# The North Wales Wind Farms Connection Project

Environmental Statement Chapter 2 - Description  
of Proposed Development Technical Appendices  
Outline Hedgerow Management Plan Version 4 -  
Tracked Change Version

Application Reference: EN020014

Document Reference No.	6.18C
Regulation No.	Regulation 5(2)(a)
Author	SP Manweb
Date	December 2015
Version	V43
Planning Inspectorate Reference No.	EN020014

ELEVATION OF NATIVE HEDGE Scale 1:20

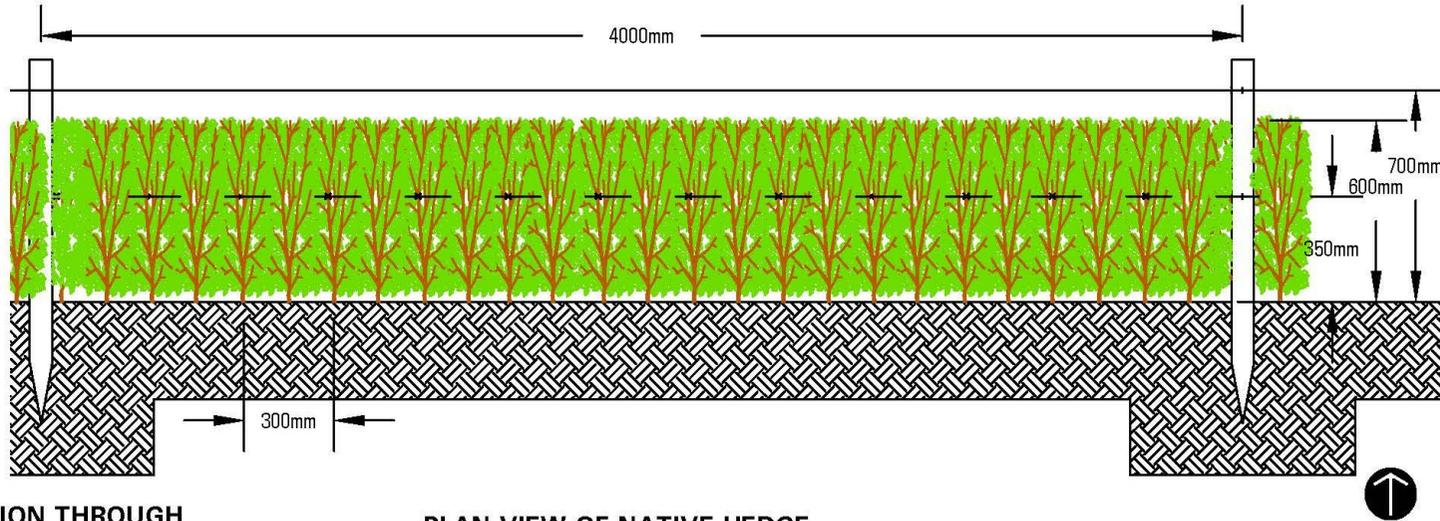
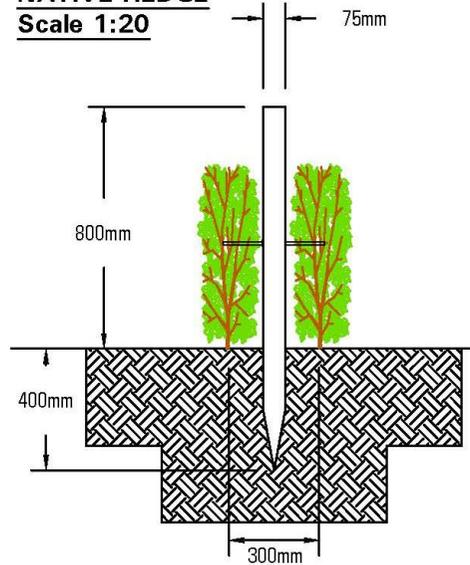
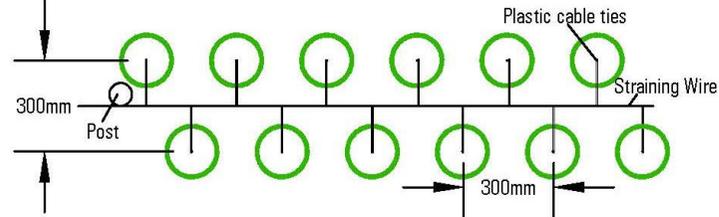
- 2.6.4 Planting shall be at a density of six plants per linear metre in a double staggered row in accordance with the proposed species mix. All newly planted hedgerows shall be protected to prevent damage to the young plants from livestock. Rabbit-proof fencing shall be installed where necessary. A standard detail for hedgerow planting can be found in Appendix 1.
